DECISION DELEGATED TO DEVELOPMENT MANAGER

Application No:	H11-0957-18	Applicant:	Mr Matthew Footitt
Proposal:	Residential development- erection of 3 bed, two-storey dwelling with off road parking		
Location:	84 Roman Bank Long Sutton Spalding		
Terminal Date:	12th September 2019

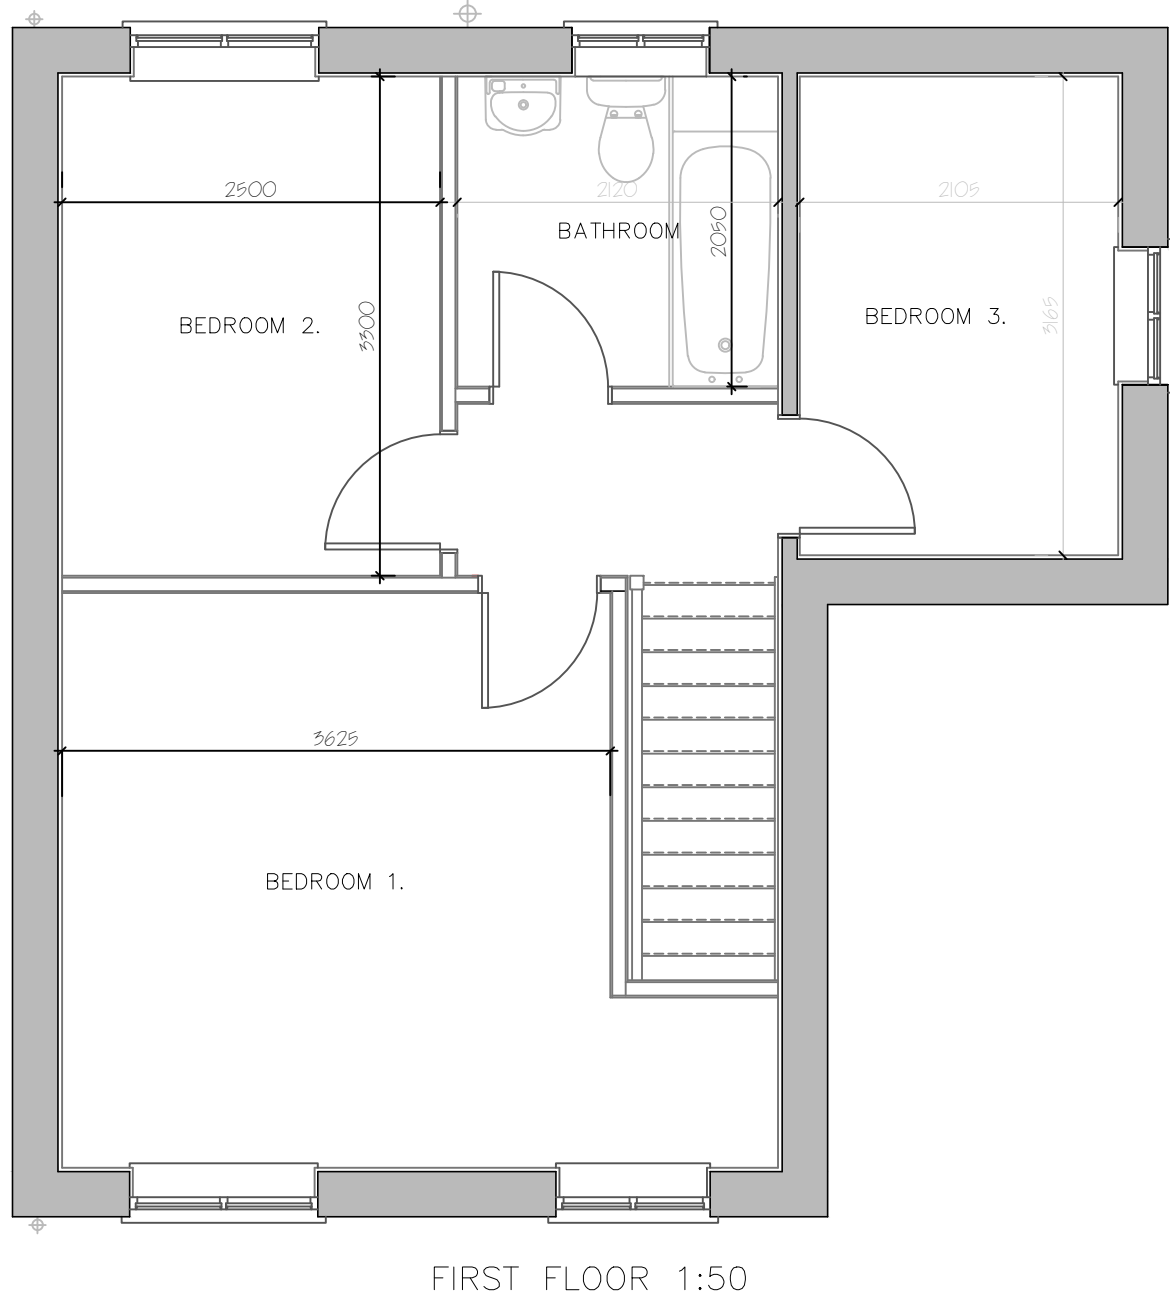
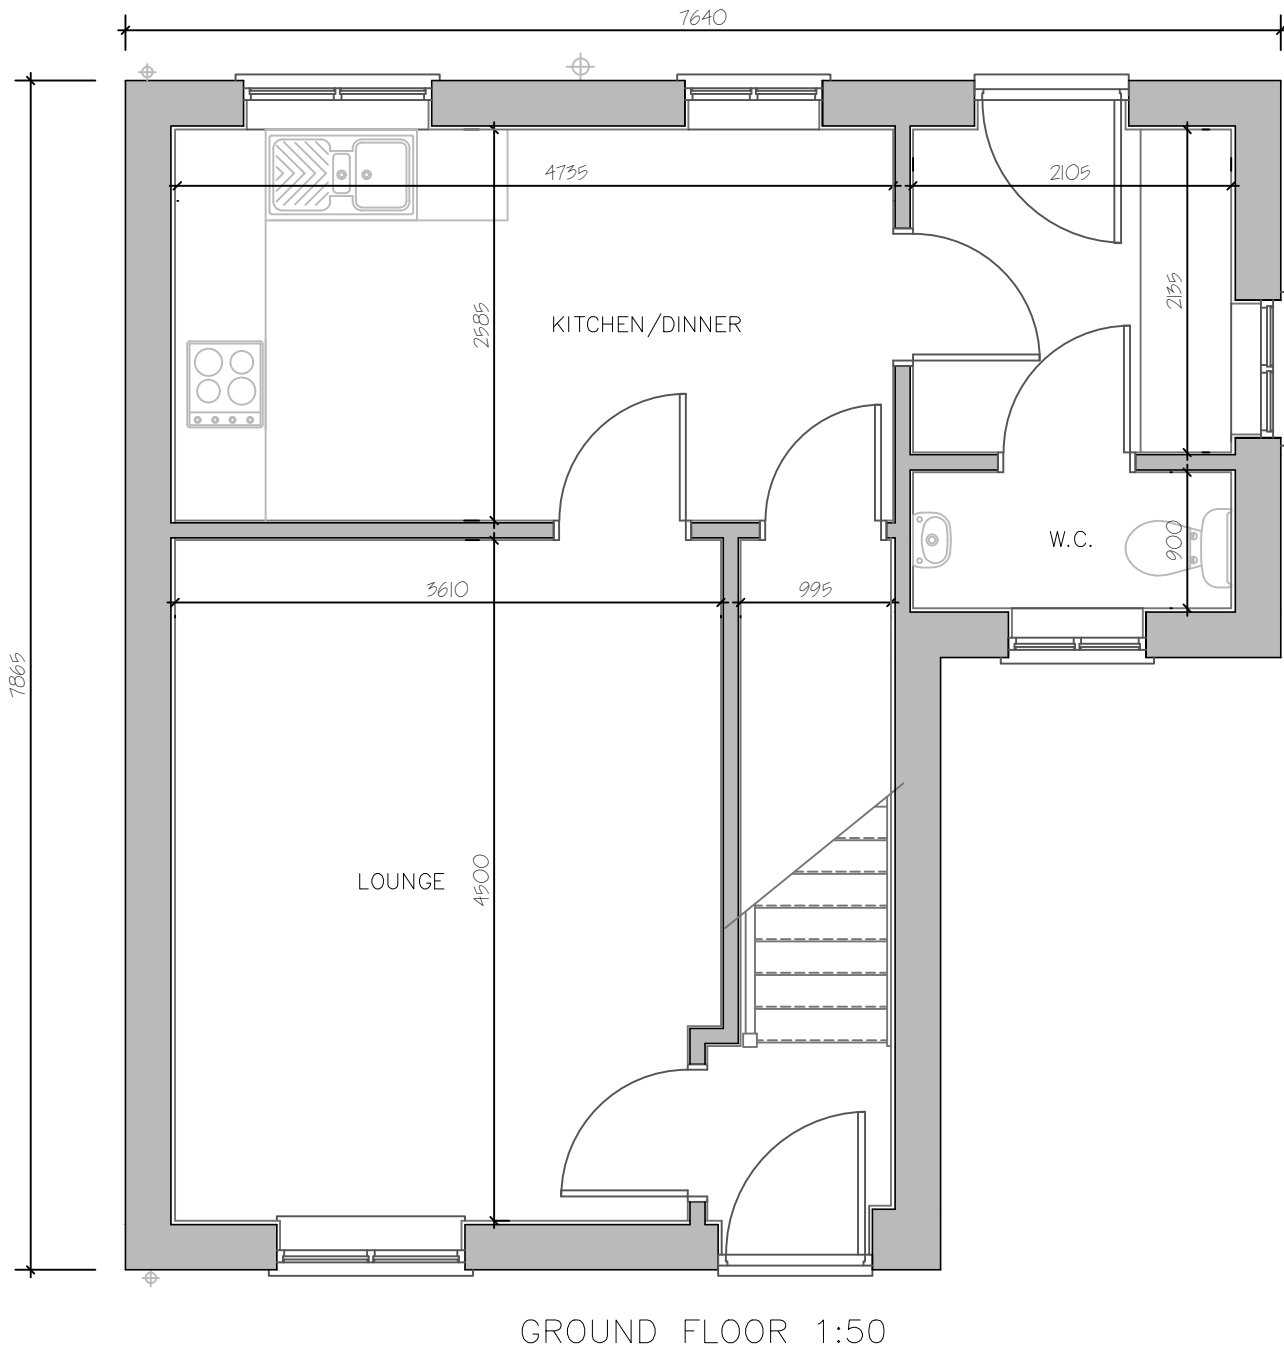
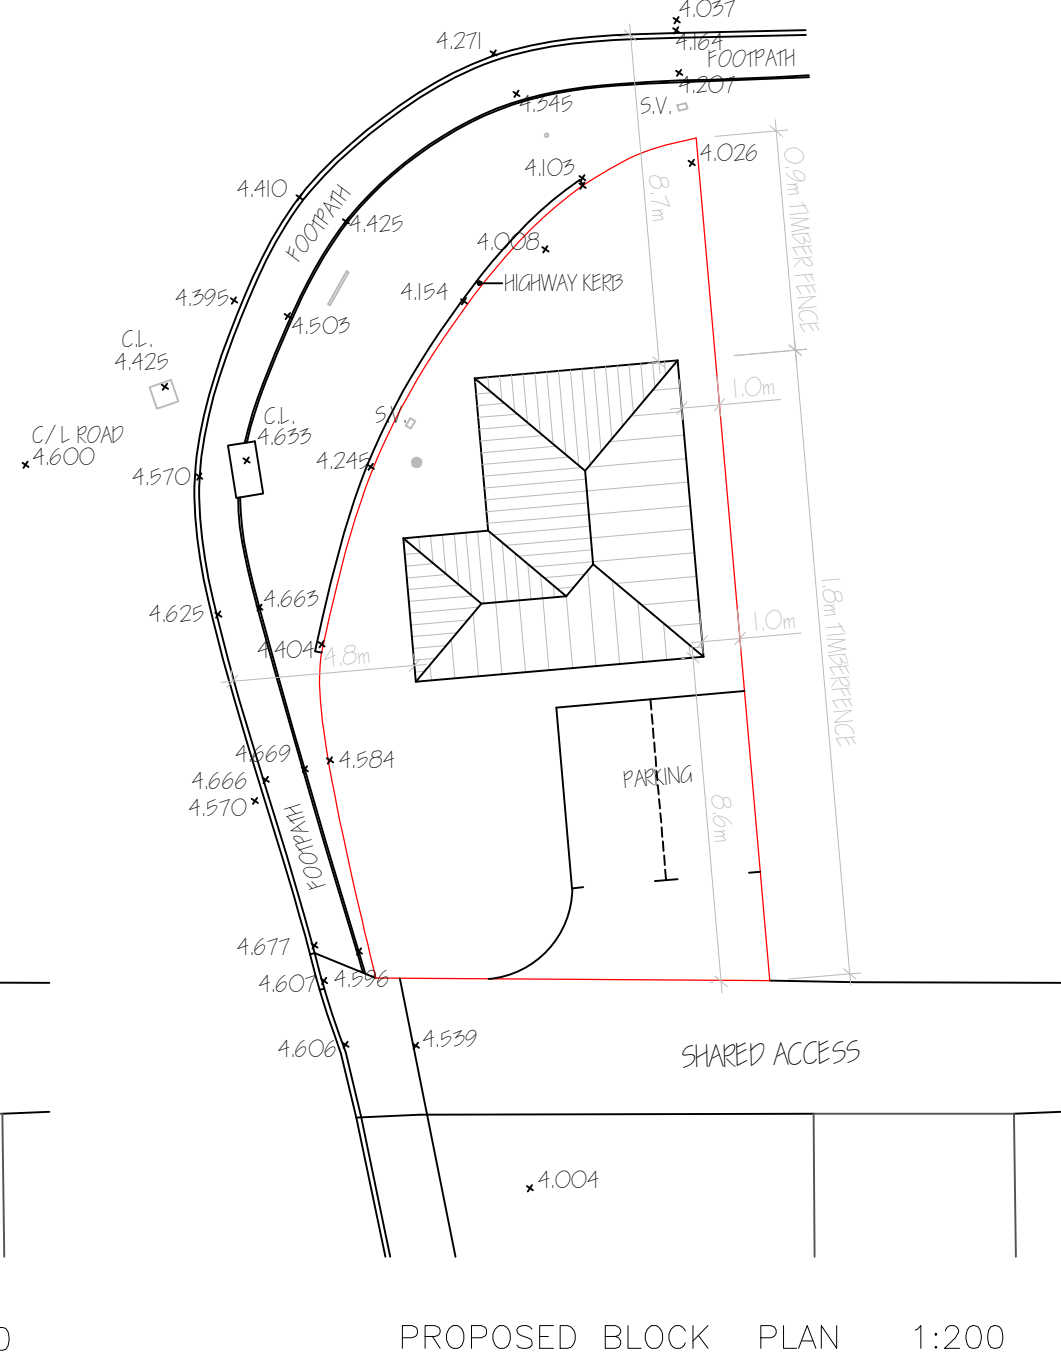
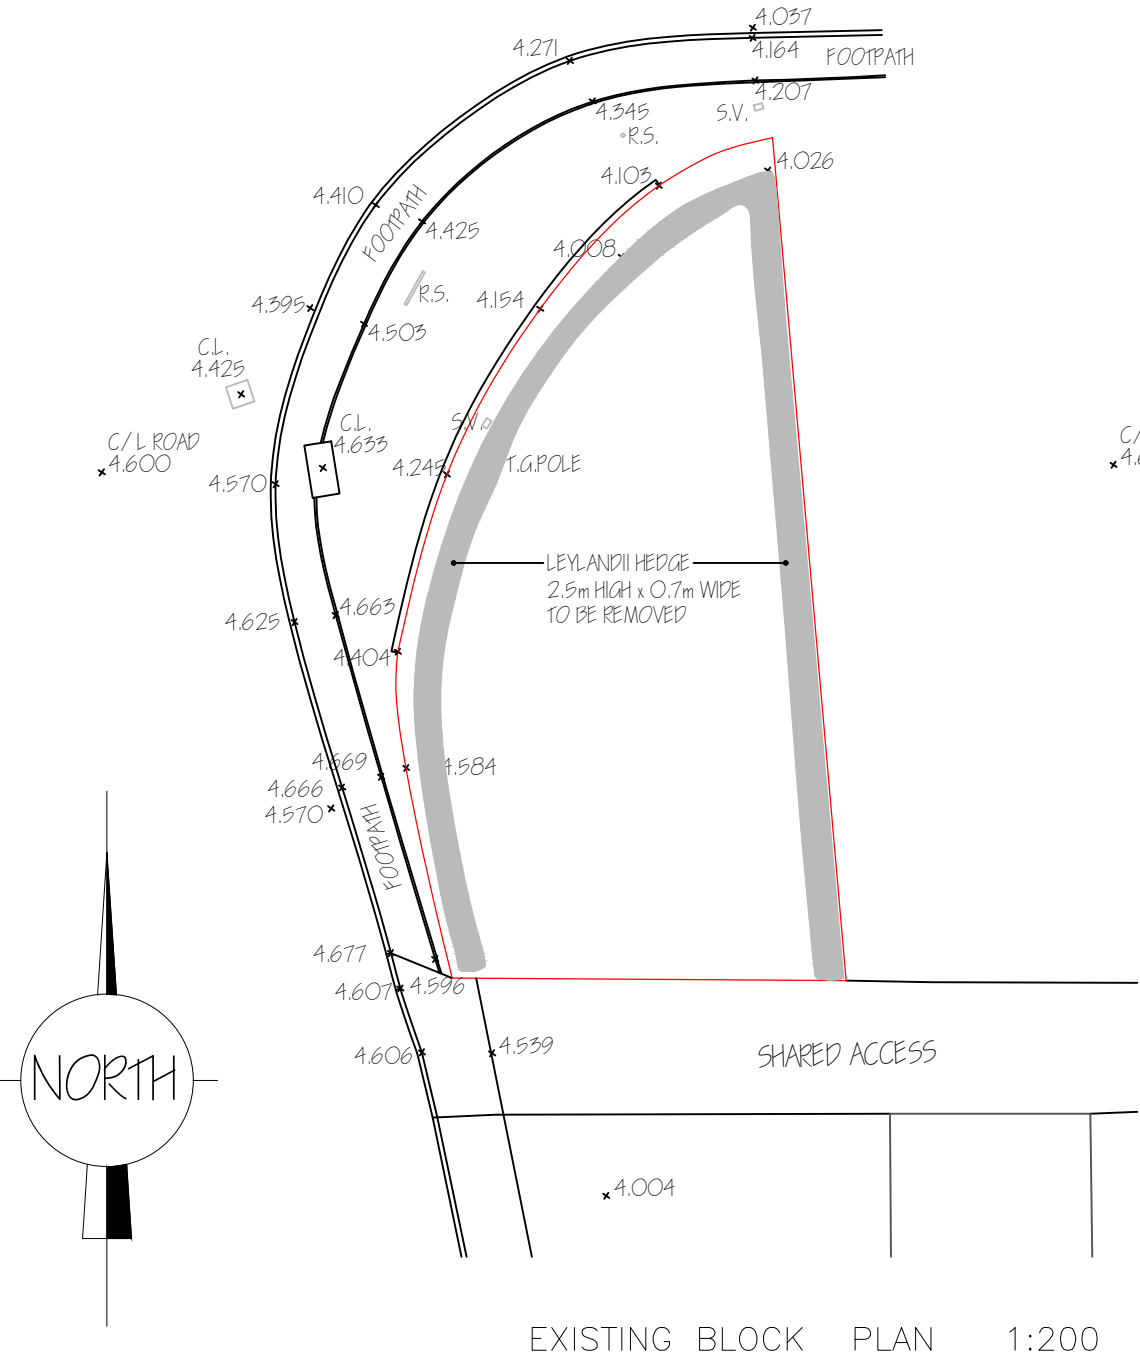
Although this is only an outline application, the applicant has specified that the proposed dwelling would be two-storey in nature and has submitted a drawing indicating what the dwelling could look like. In comparison to the previously refused application, the height of the ridge and pitch of the roof has been dropped by roughly half a metre. The dimensions of the building (excluding the roof), position, orientation, internal layout and raised floor level due to flood risk remain identical as well as the boundary treatment, site access and parking provision on the site.

As discussed in the officer report of the previously refused application, the site is situated in a prominent location on the corner of Roman Bank and Woad Lane and any dwelling would be sited further forward of the building line than 84 Roman Bank. It is not considered that there has been any material change in circumstance since the previous application in terms of this and so the proposed development would still remain at odds with the existing character and pattern of development in the area. The character of dwellings within closest proximity to the site are terraced and semi-detached dwellings, part bricked and part rendered. A detached dwelling like that proposed would be at odds with this.

A dwelling could be designed so as to not result in any overlooking however, having regard to the likely scale and cramped form of the proposed development, it is considered that an overbearing impact would likely be created upon the residents living in the nearest properties.

Whilst the Standing Advice included in the SFRA indicates that finished floor levels must be set 300mm above ground level given such flood hazard and depths, the Flood Risk Assessment that accompanies the planning application proposes to raise internal floor levels 150mm above ground level. The proposal therefore would not be fully comply with the minimum requirements to make safe both the dwelling and its occupiers to any flood risk.
